My name is [REDACTED] **Morningthorpe and Fritton Parish Council.**

East Pye Solar - EN0110014

Morningthorpe and Fritton Parish Council – Follow-up from ISH1

Site Location Plan: Site 5

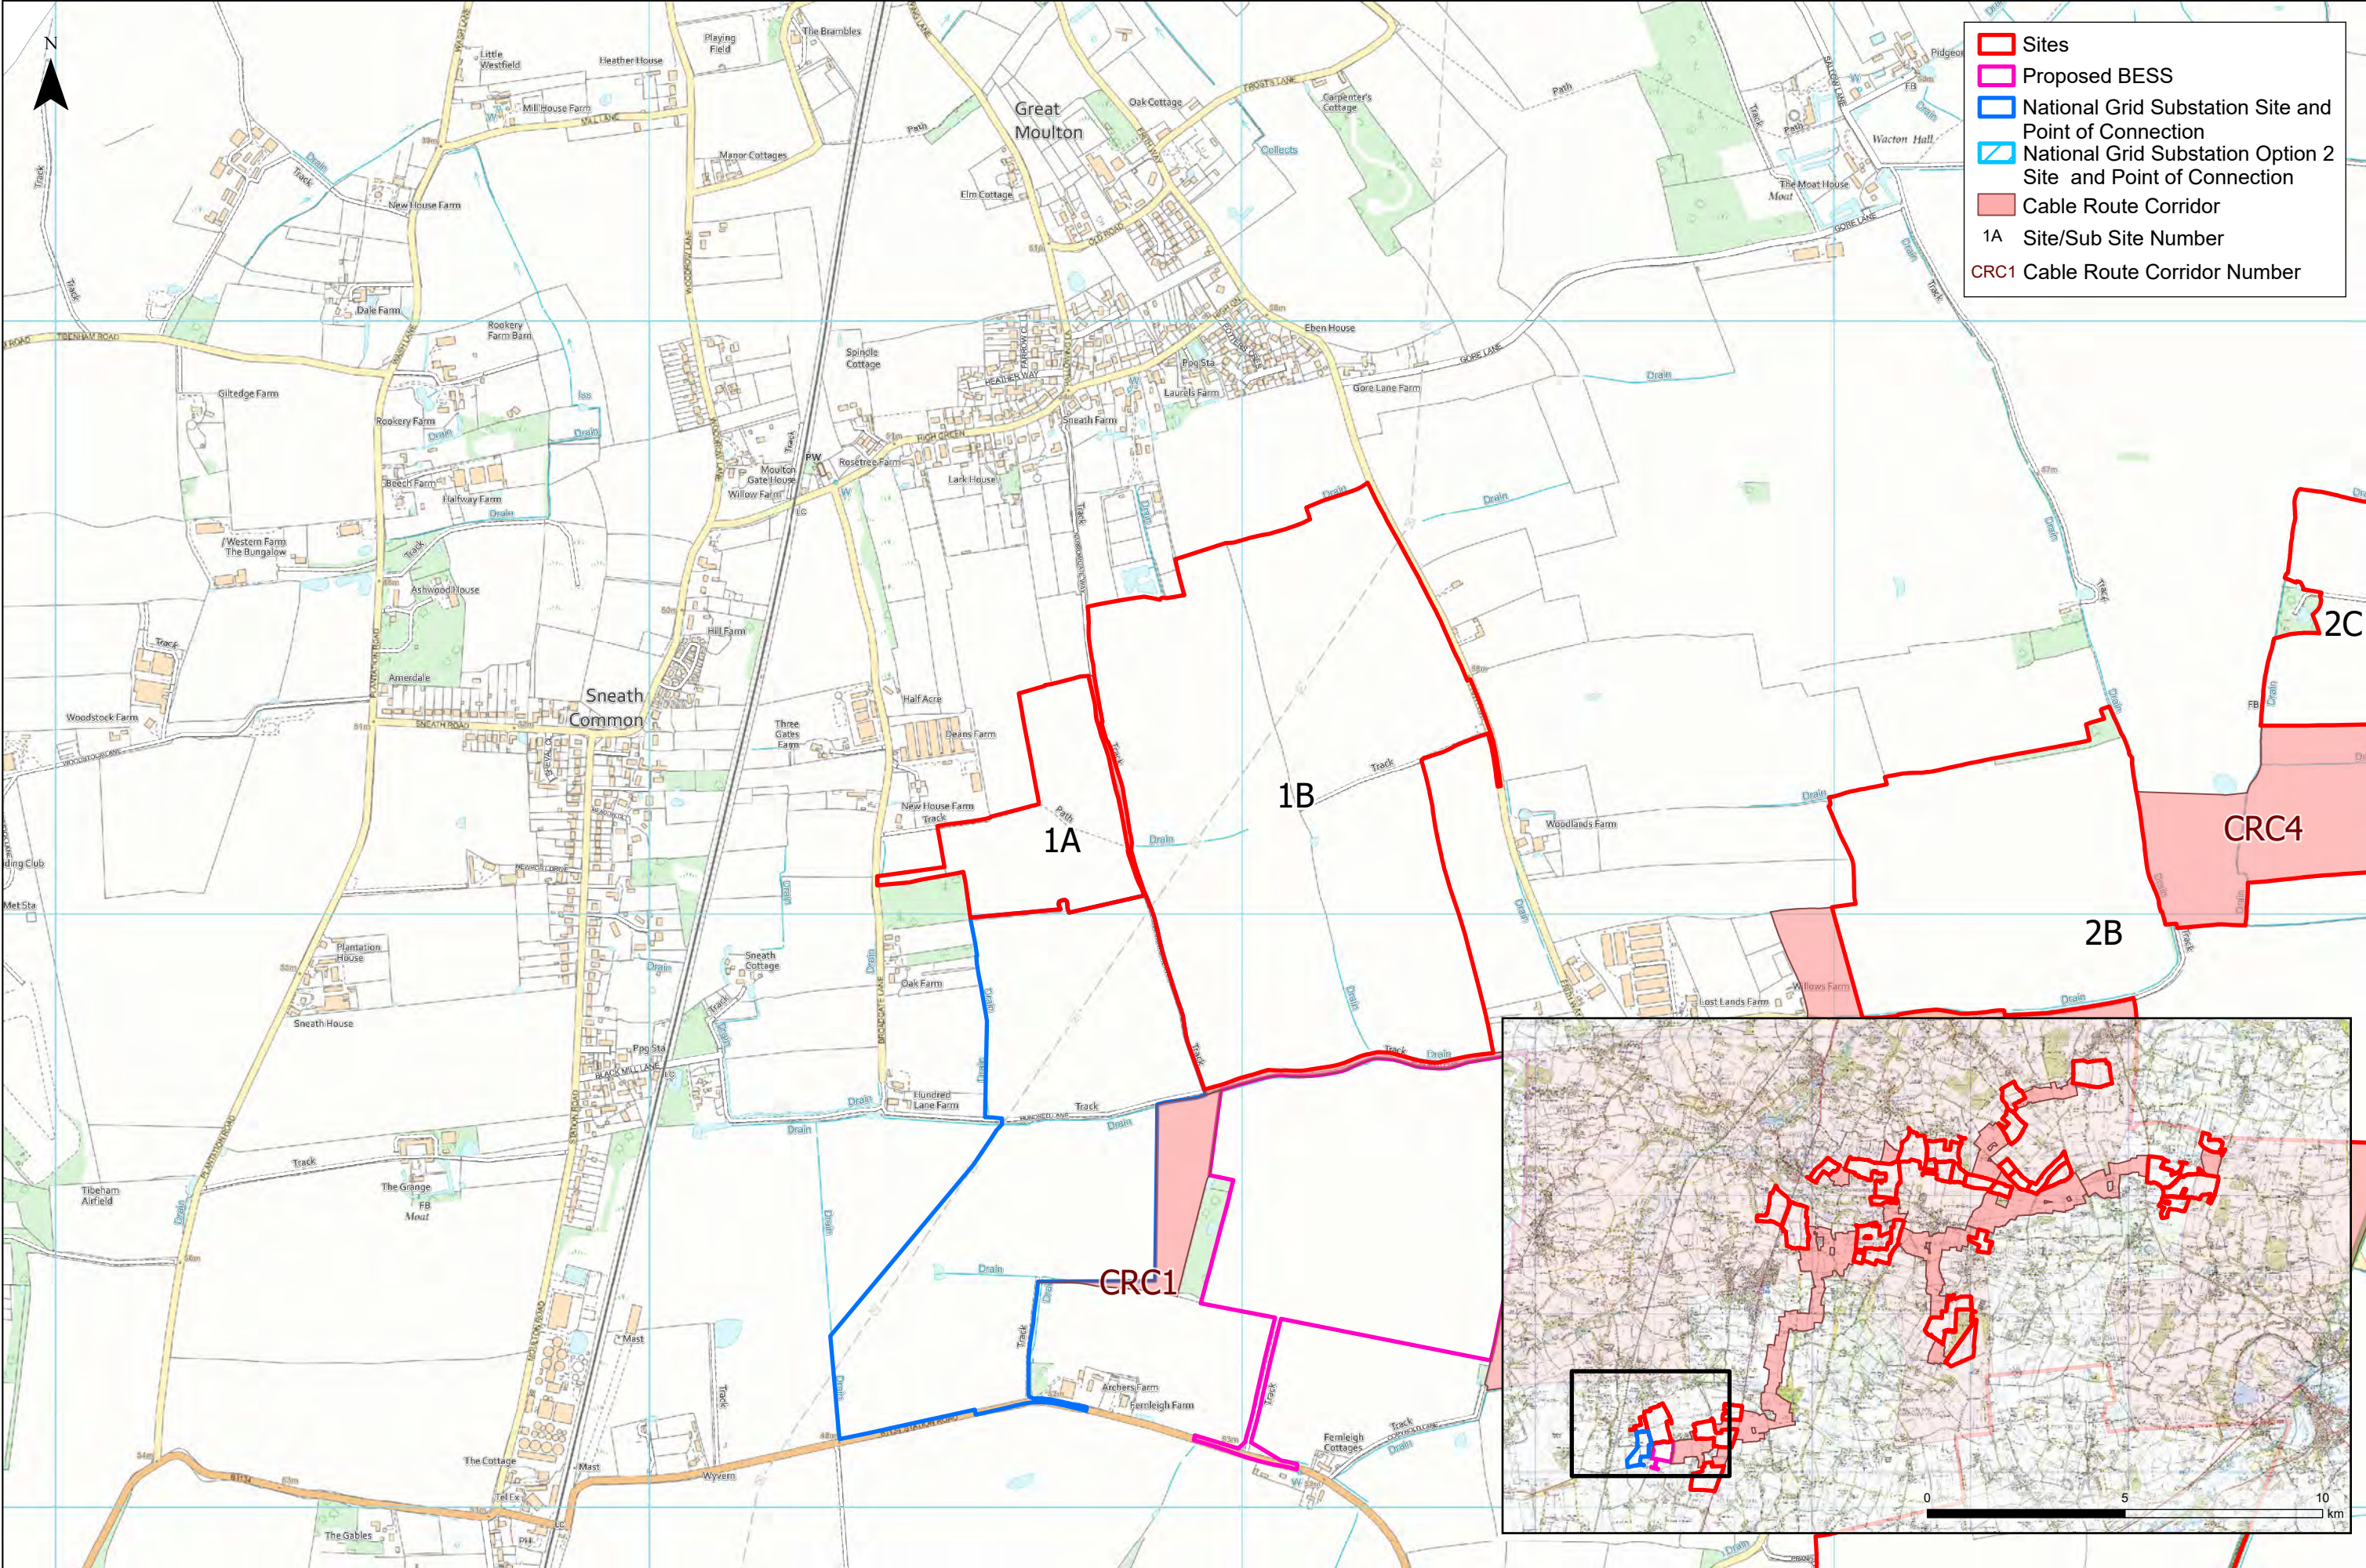
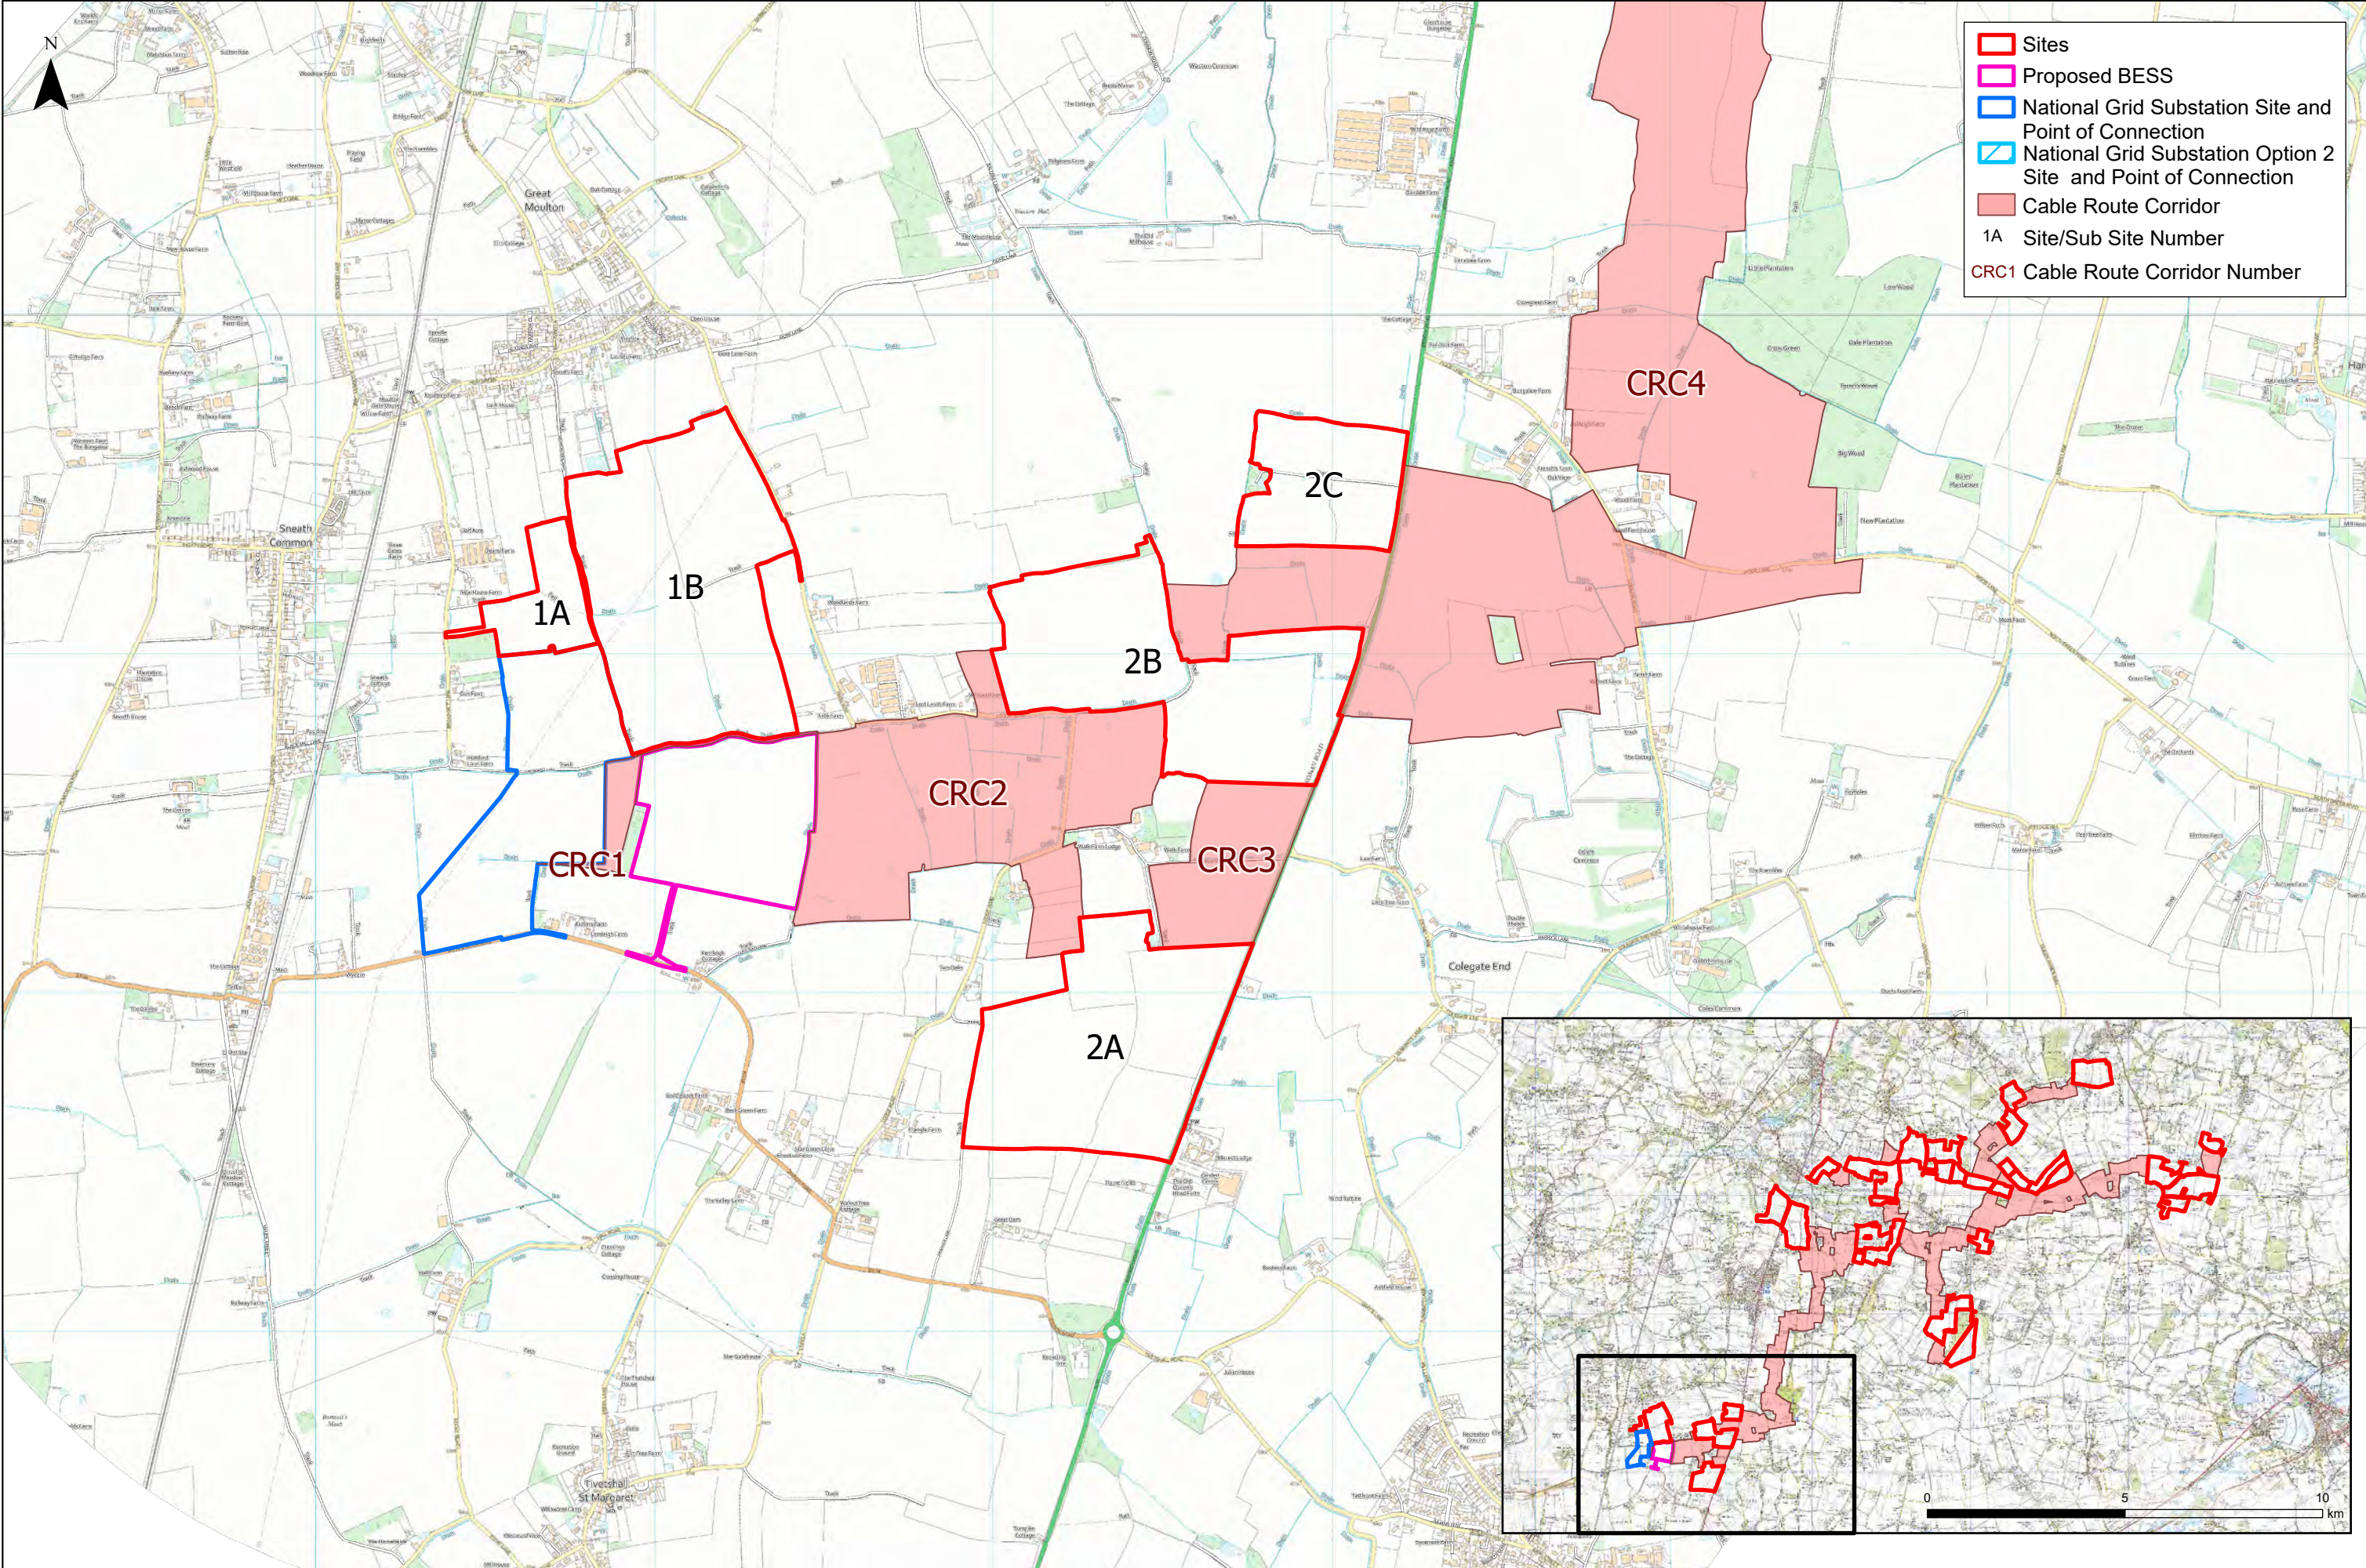
Site 5 would introduce a **13m high 400kV substation, 4.5m high tracking panels, transformers, construction compound, fencing, lighting and CCTV** into countryside in and around Fritton and Morningthorpe.

Site 5 contains many of the very constraints the Applicant says should be avoided: sensitive landscape, nationally important heritage, high-quality agricultural land, ecology and nearby homes. Yet the Applicant has not demonstrated that Site 5 is the least harmful location.

Yet our review identifies 7 residential properties omitted from the construction-noise assessment, 4 for vibration assessment distance, and 6 for the highway noise distance. Approximately 70 residential properties lie within 500 m of Site 5 for operational noise and have been omitted.

Site 5 also occupies much of the northern foreground when approaching Fritton, where the transition from open countryside into the historic village remains remarkably intact.
